## LU/220/18/PL

The proposal is for change of use and alterations to the external appearance of the building.

EAST + NORTH ELEVATIONS - PROPOSED
70 HIGH STREET, LITTLEHAMPTON, SUSSEX.
GRAHAM NICOLLS LTD.

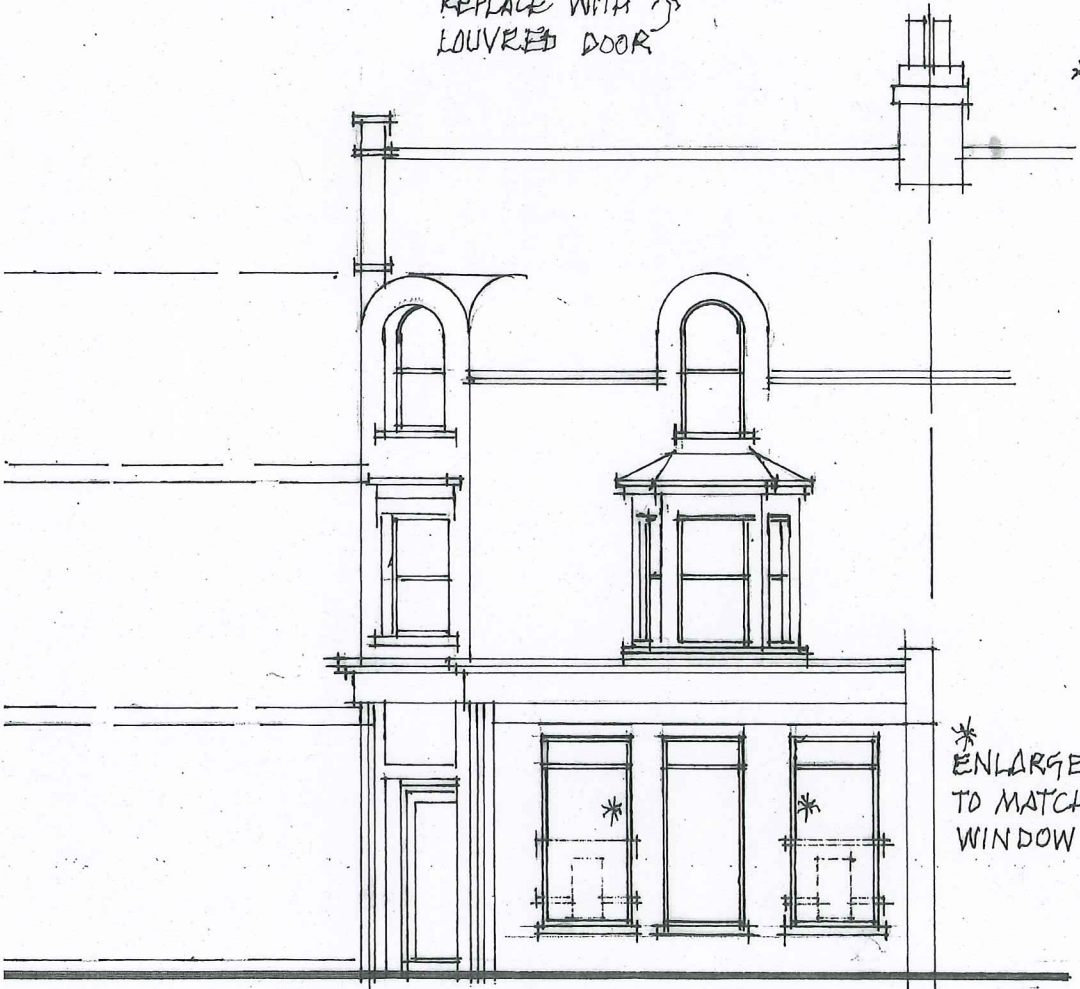
The north and east elevations are the most significant form the perspective of the buildings significance. The concept of lowering the windows is understood and accepted as a means of enabling the continued use of this element of the ground floor as a retail unit. However, the means of lowering the windows may be problematic, and should be designed so that they read exactly as the other ones already on the ground floor. Details of the windows and their surrounds will need to be provided to the council by way of condition, so that there is the opportunity to ensure that the works match the existing.

If minded to approve the application, please provide ensure that the joinery details matching those already present, and that details of the ground floor shop windows and their surrounds be provided by way of condition.

SOUTH + WEST ELEVATIONS - PROPOSED

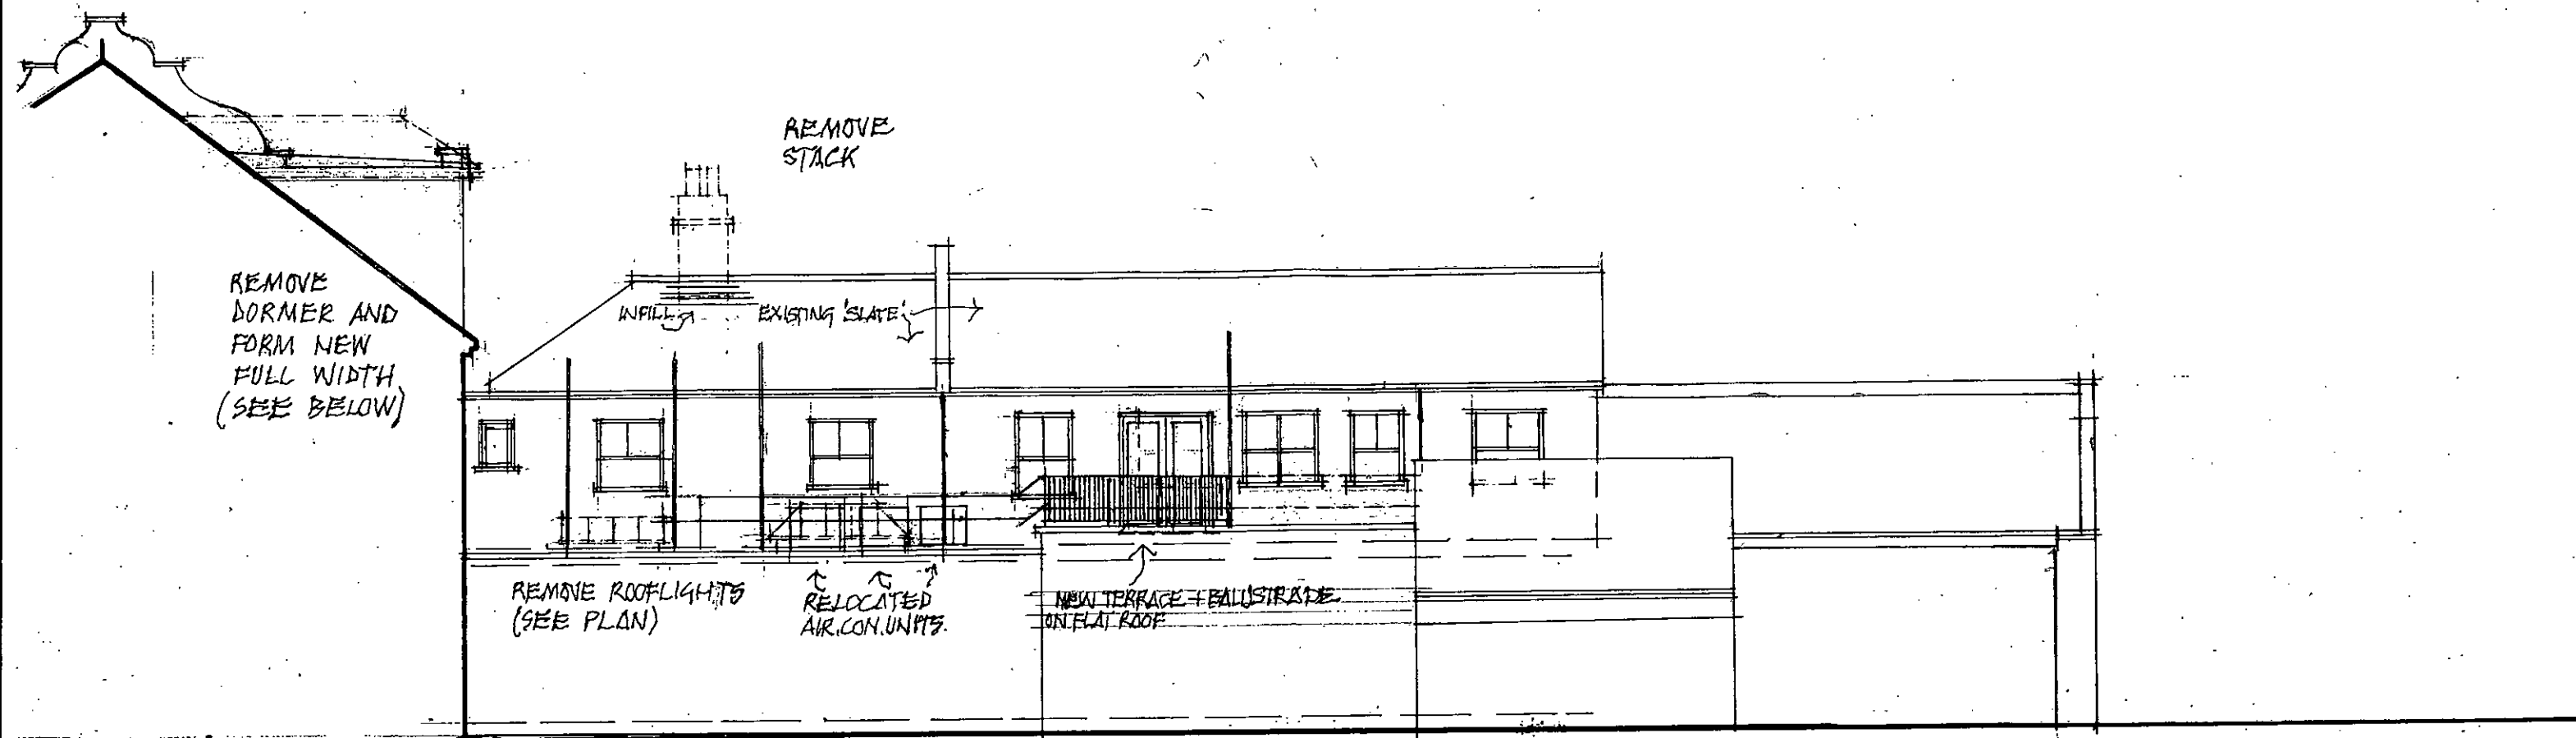
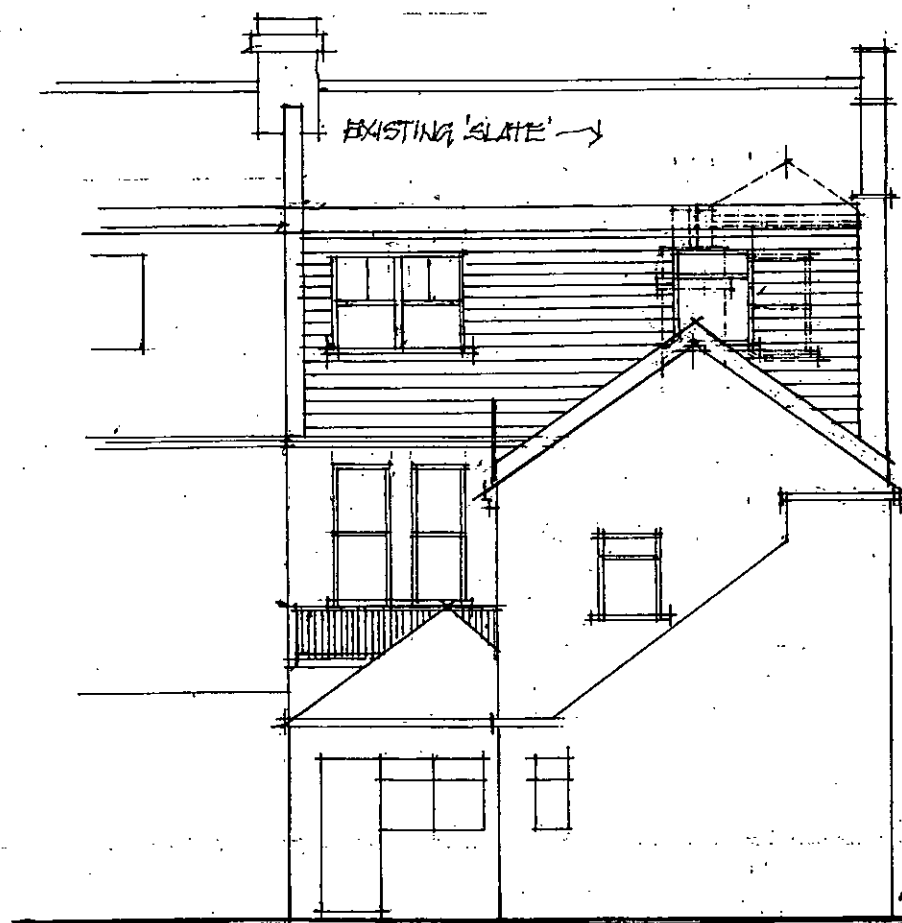
The rear dormer is large in scale, but is not necessarily significantly visible from the public realm. However, it is considered to be bulky in nature, and it is thought that a modestly scaled dormer of traditional proportions would be better placed in this location.
